Our Ref: PA/1282/sf  
Your Ref: S6/2017/1176/PN11 and S6/2011/1994/MA

**Blackhorse House, 36 Salisbury Square, Hatfield**

I refer to the above prior notification application for the “prior approval” for the change of use from office (B1a) to a dwelling house (C3) to include the creation of 16 x 1 bedroom flats.

TITLE
PARKING PLAN

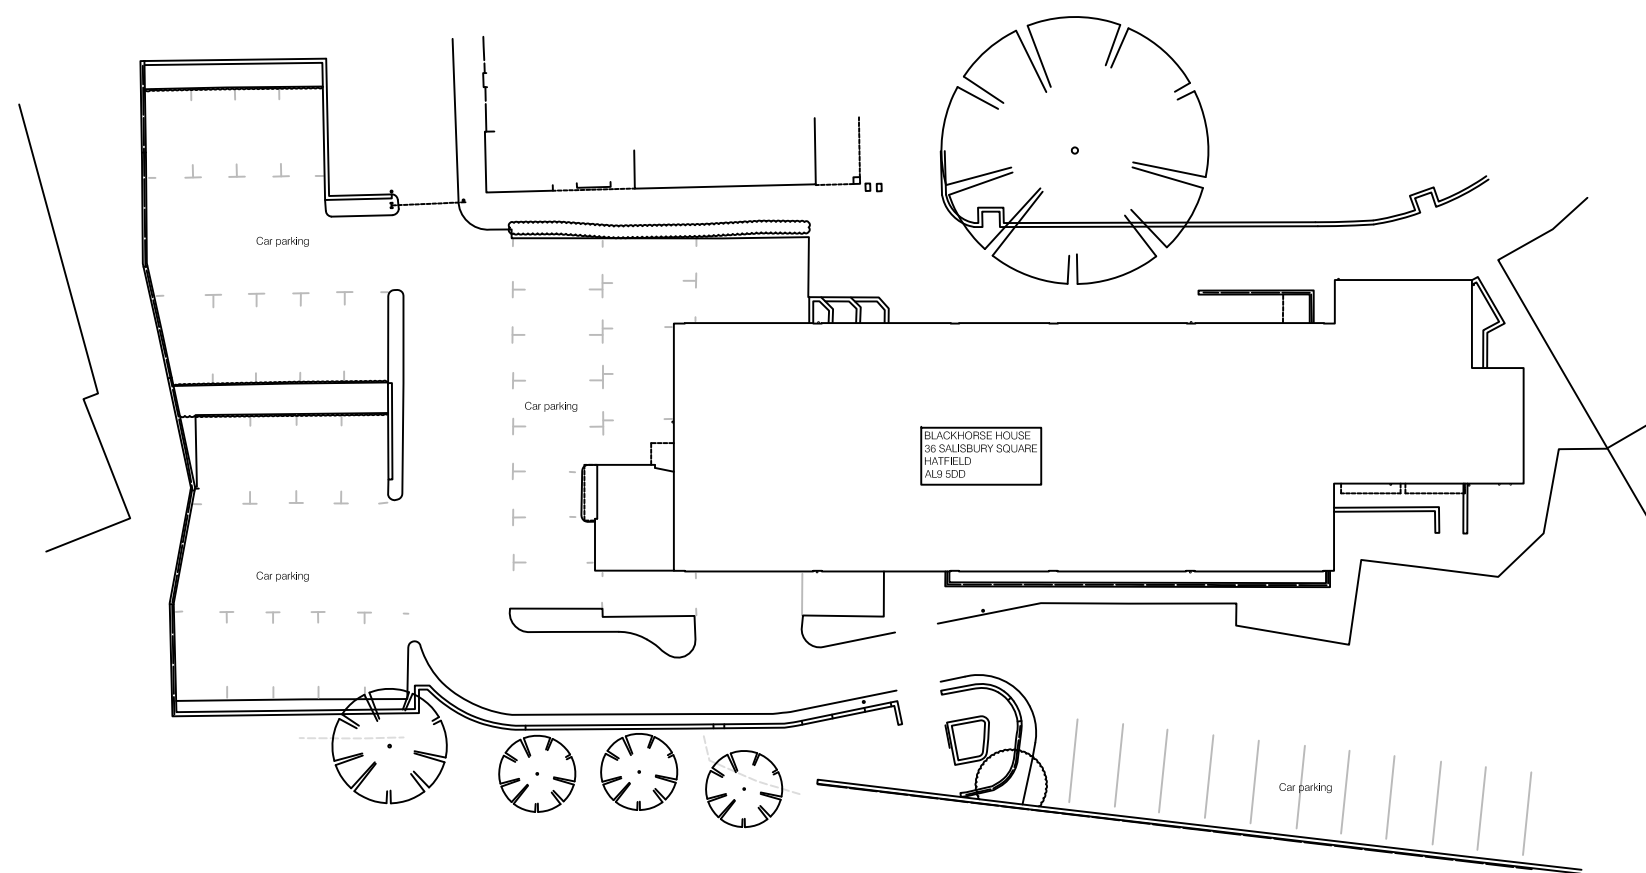
I refer to submitted Drawing SK003A – Proposed Parking Plan, which utilises existing parking spaces. This plan clashes with the approved parking plan, pedestrian thoroughfare and priority area linking across from Hatfield Station into Salisbury Square. Please see attached Drawing 789-1090 dated January 2011.

I understand from the Town & Country Planning General Permitted Development Order Prior Approval Regulations, that any approval for change of use from B1 to C3 dwellings/flats is required under the Regulations to be carried out in accordance with the submitted details. Clearly, therefore there is a clash between the two schemes which requires remedy.

Whilst Gascoyne Cecil Estates do not wish to frustrate the Blackhorse House scheme for the creation of flats, this proposal as it stands should be refused on highway grounds unless an amended plan is submitted. Without this amended plan, the Blackhorse House scheme will undermine the approved Salisbury Square development which has been fully designed and prepared with the support of the local Old Hatfield community, Welwyn & Hatfield Borough Council and local stakeholders including Hertfordshire Highways.
